GEOSCAPES Reference: # 231107\_SSD\_LET\_RTC01

Re: **Glendenning Road Data Centre, 2 Glendenning Rd, Glendenning NSW 2761 (SSDA 73761707) - Response to Submissions – Landscaping and Visual Impact.**

Please find below our responses to recent comments raised by the DPHI regarding the Landscape Plans and VIA prepared by Geoscapes for the above-named project.

PROJECT: GLENDENNING ROAD DATA CENTRE
TITLE: SECTIONS A-A & B-B
DRAWING: GRDC86-GEO-00-XX-DR-SSDA-L-0200
PAPER SIZE: SCALE: 1:100 @ A0
AGILE NO: G
REV: G
PRINT IN COLOUR

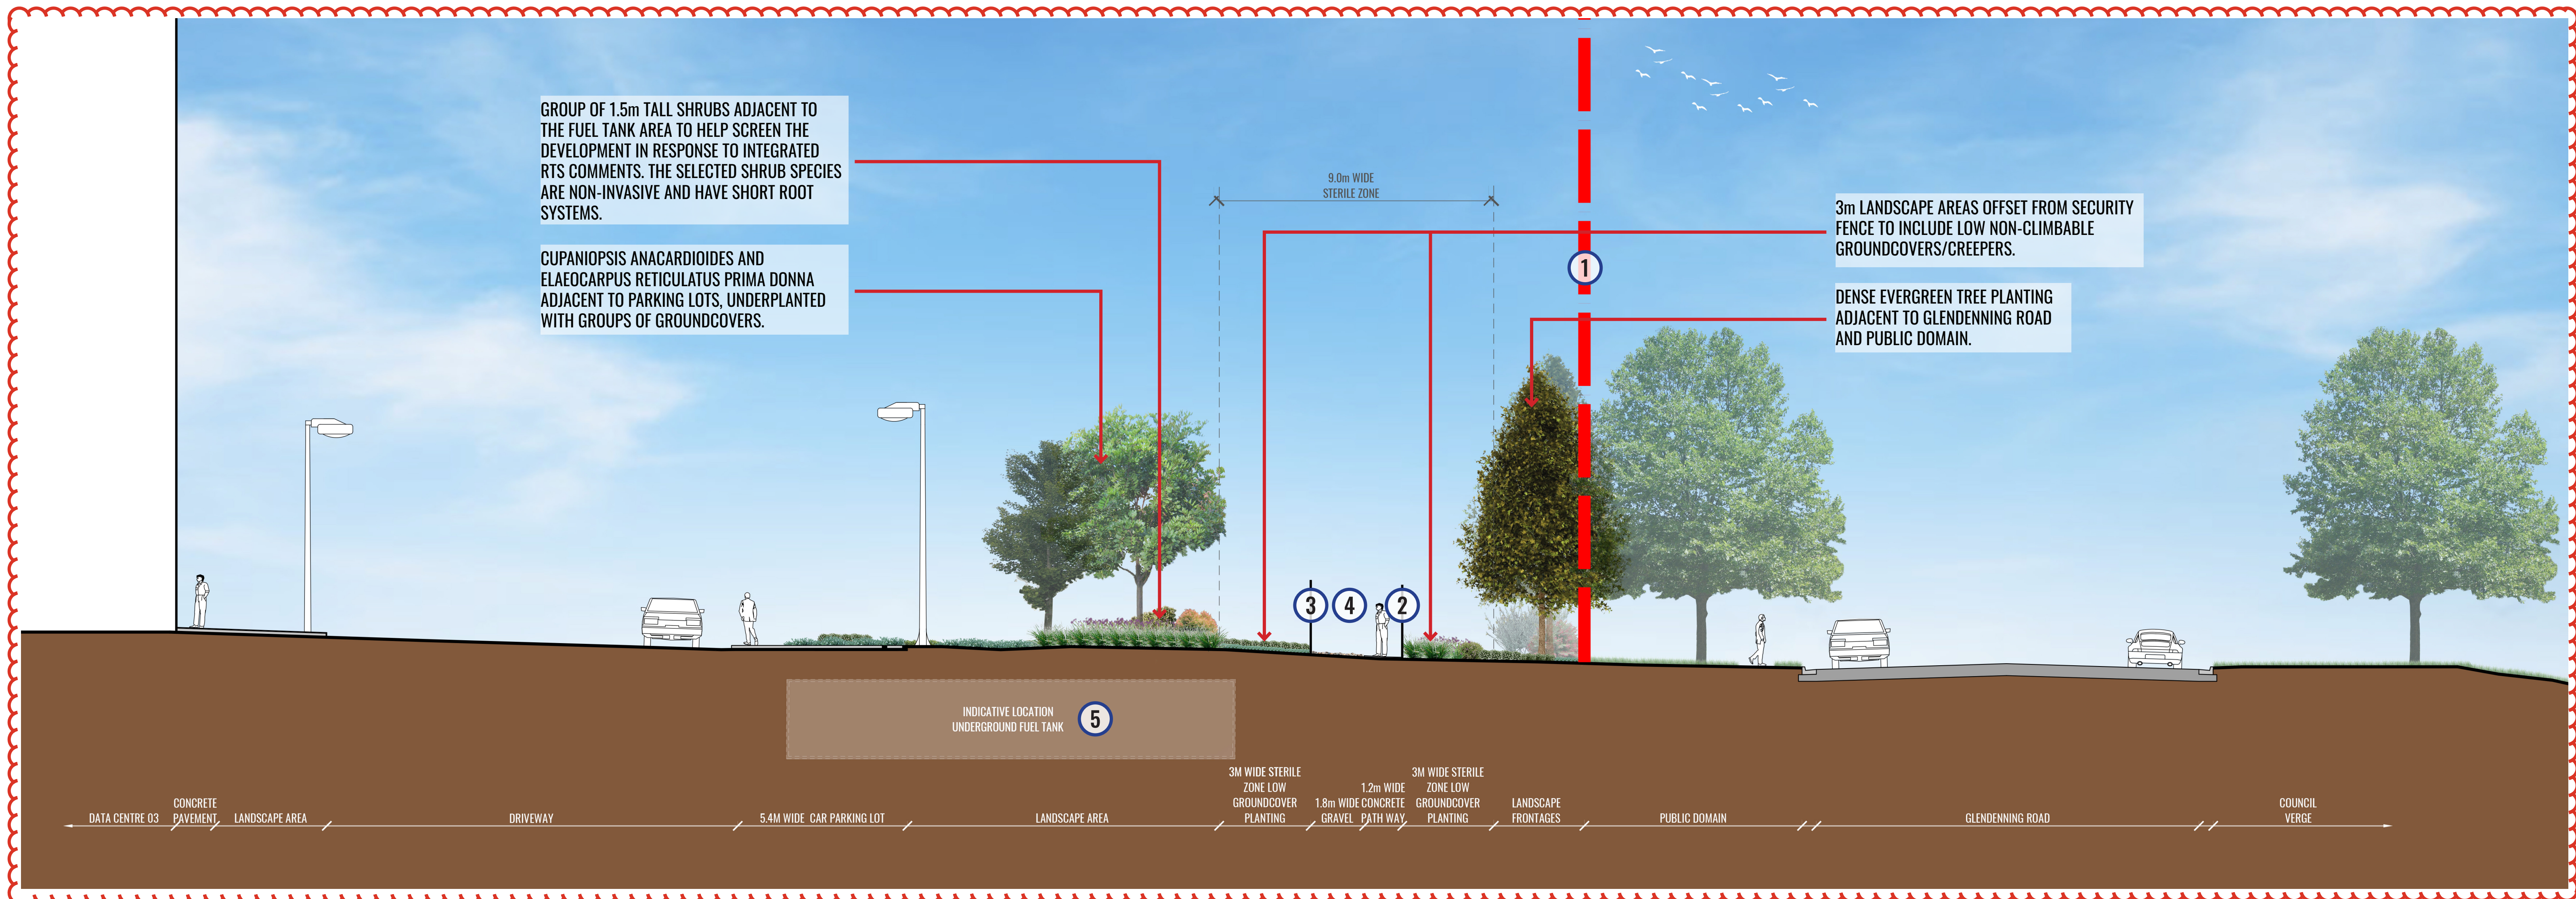
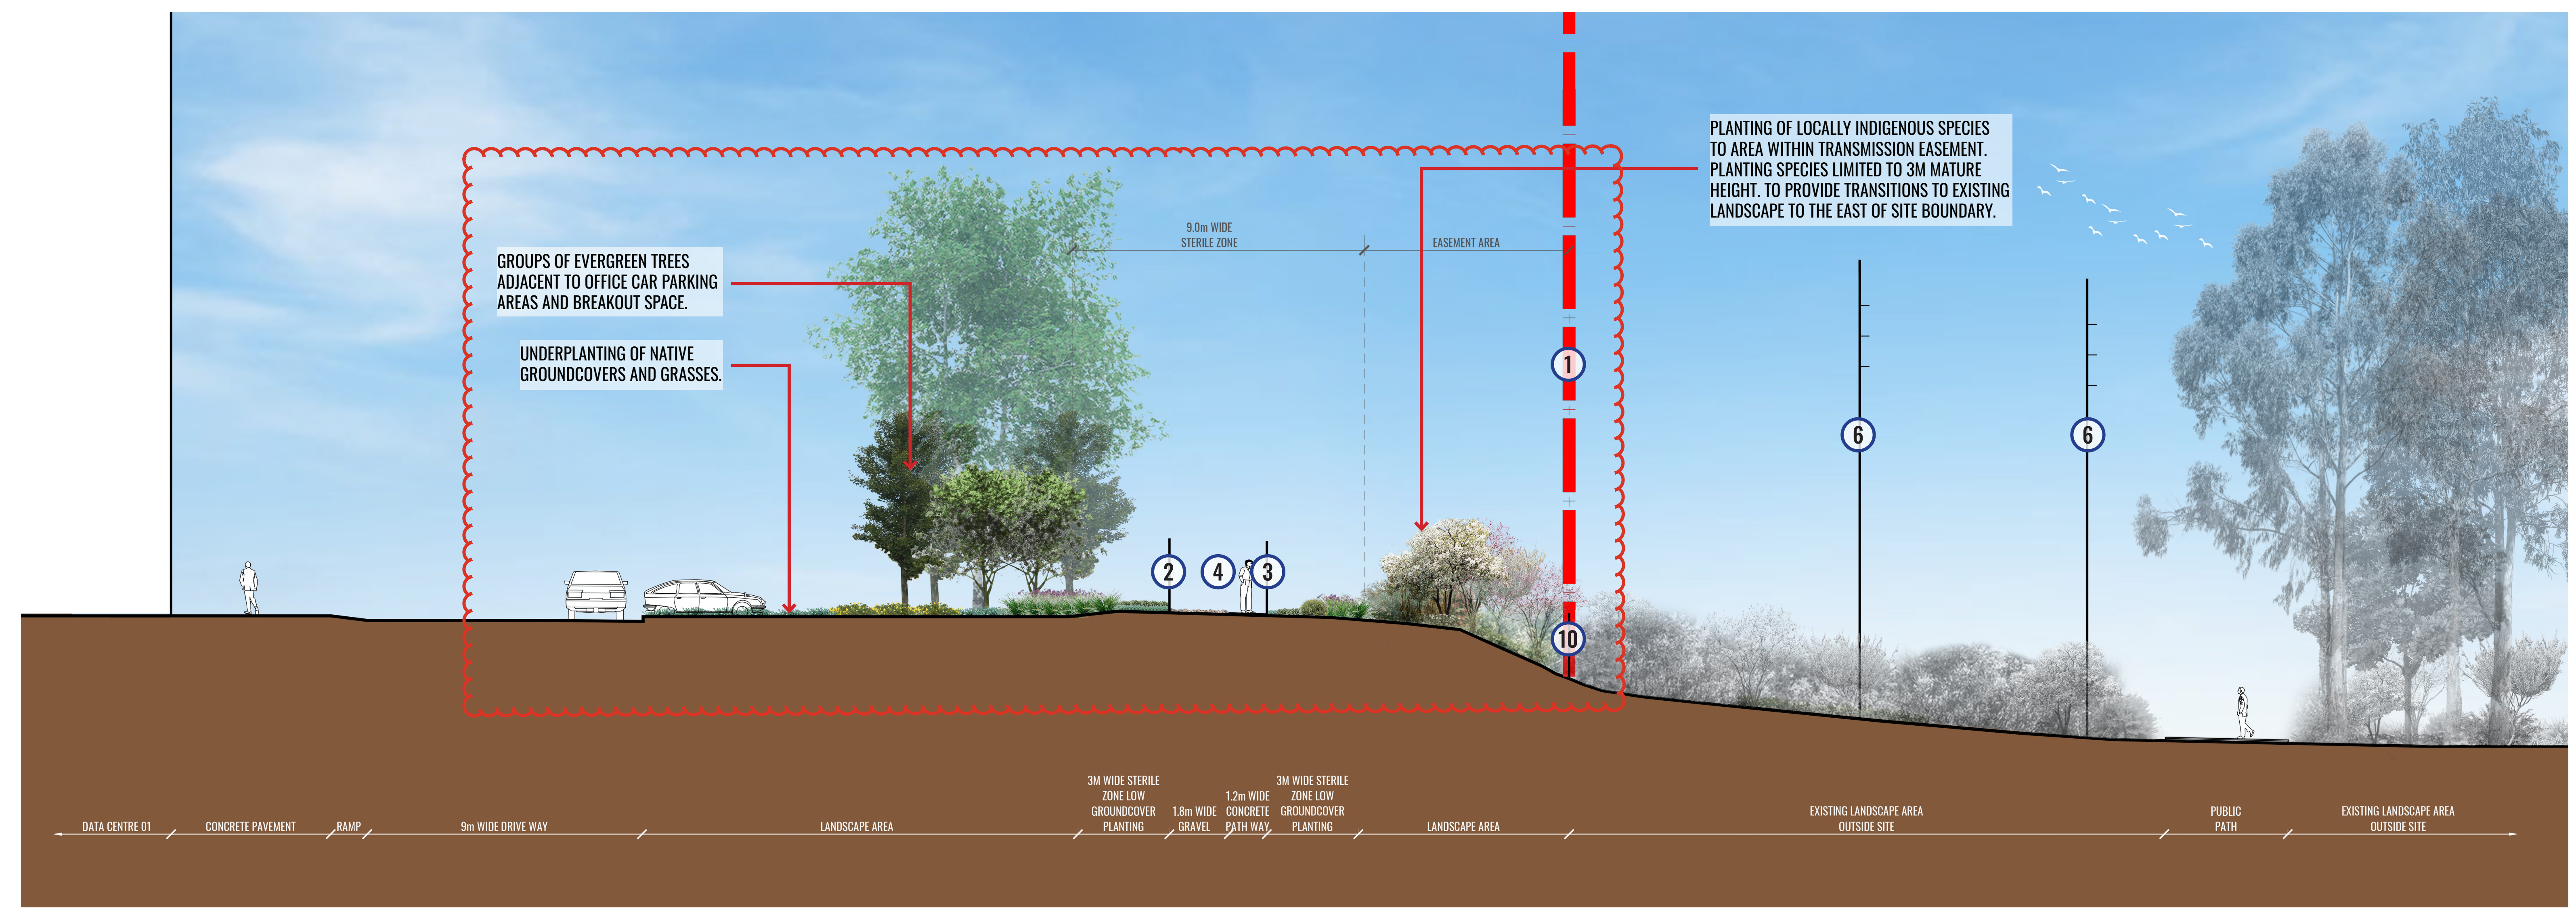
*d. Provide additional landscaping and tree planting in the front landscaped setback area adjacent Glendenning Road. Underground fuel tanks are also proposed in the landscape setback which compromises the opportunity for dense landscaping in the front setback. These tanks should be relocated accordingly.*

**Geoscapes Response** – Refer to Proposed Tree Locations & Services Plan Overlay on L-0003. Landscaping in this area is constrained by underground services and the placement of underground fuel tanks. Refer to Detail Plan on L-0100 and Section A-A on L-0200. To address this, the following changes have been made:
